From: [Stephanie Moore](#)
To: [Kelly Bacon \(CD\)](#)
Cc: valw@apssm.com
Subject: RE: SP-20-00005 Zipperer - RFI and Transmittal of Comments
Date: Monday, September 14, 2020 11:10:59 AM

From: "Kelly Bacon (CD)" <kelly.bacon.cd@co.kittitas.wa.us>
Date: 8/27/20 12:03 (GMT-08:00)
To: justinzipperer@yahoo.com
Subject: SP-20-00005 Zipperer - RFI and Transmittal of Comments

Attached please find correspondence in regards to you short plat application SP-20-00005. I am currently working from home, therefore I am only emailing the documents. Should a hard copy of the letter and comments be needed, please let me know and I will place them in the mail as soon as possible. Please contact me directly with any questions.

ZIPPERER SHORT PLAT, SP-20-XXXX

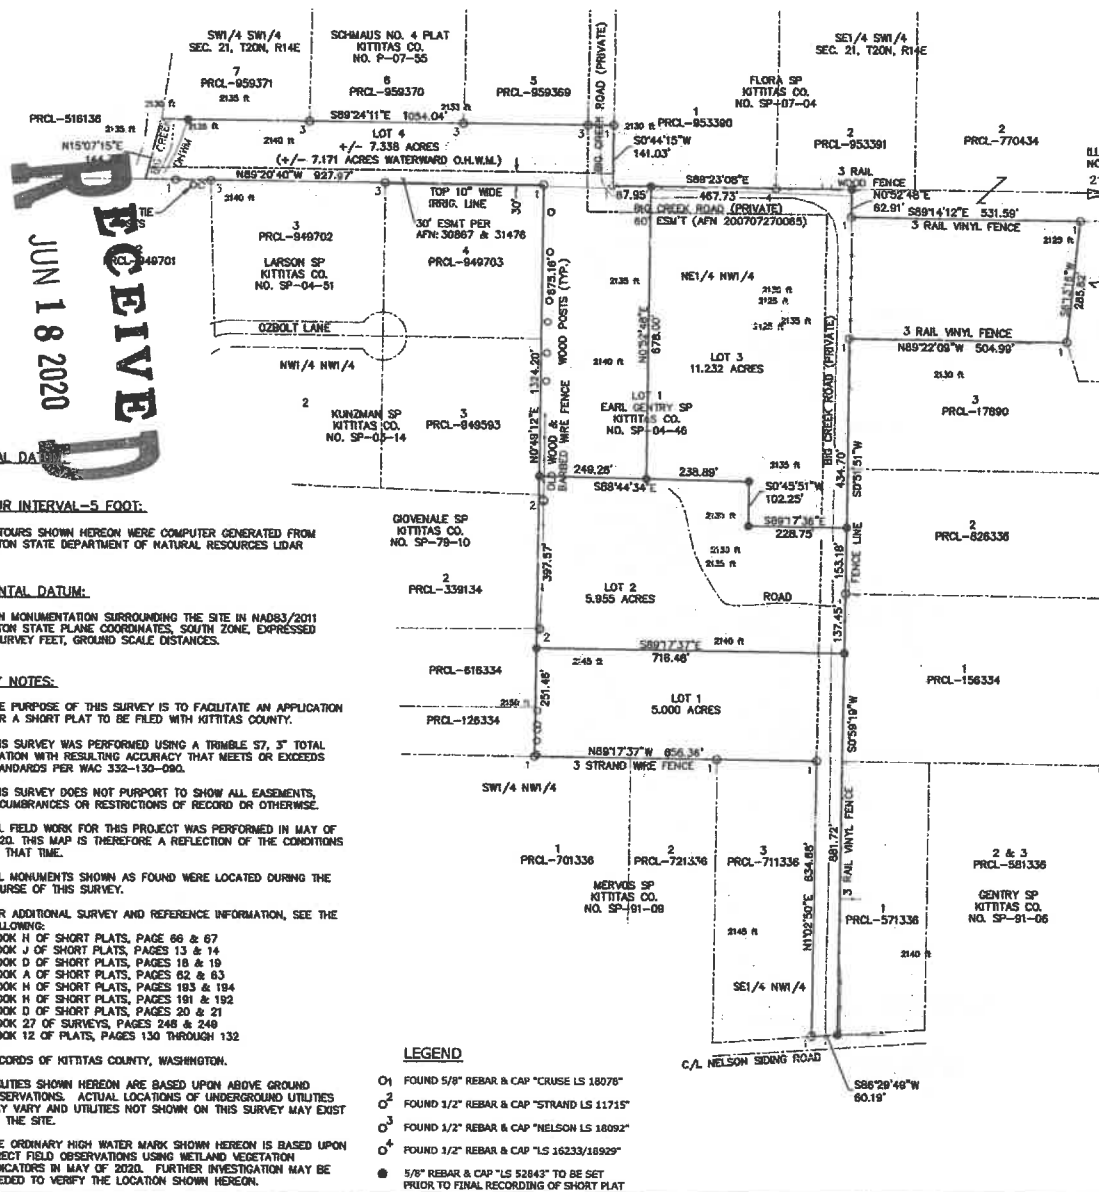
- Please see the attached septic permit. Great ground, easy gravity systems out there for any future lot owners!
- DAHP- do they just schedule a survey & come out? We punched back/took out that area by the creek & took it into acct with the lot lines! Our surveyor did advise on that.

- DOH- water- we have a well on the property & it is our intention for any future lot owners to have individual wells. It is not our plan to see off any of the land adjacent anytime soon to force a shared well. Water is good & not too deep. We don't want to be responsible to install a Group B system when sell in 10 years....

- Do we need to do something special with the KRD? What are the requirements to be met before this is approved?
- CDS- I believe Big Creek Road meets these requirements?

- WDFW- as mentioned before, our surveyor took that 200' into acct on the plat!
- Environmental Health- as mentioned, we would propose each lot have their own water source/private well.
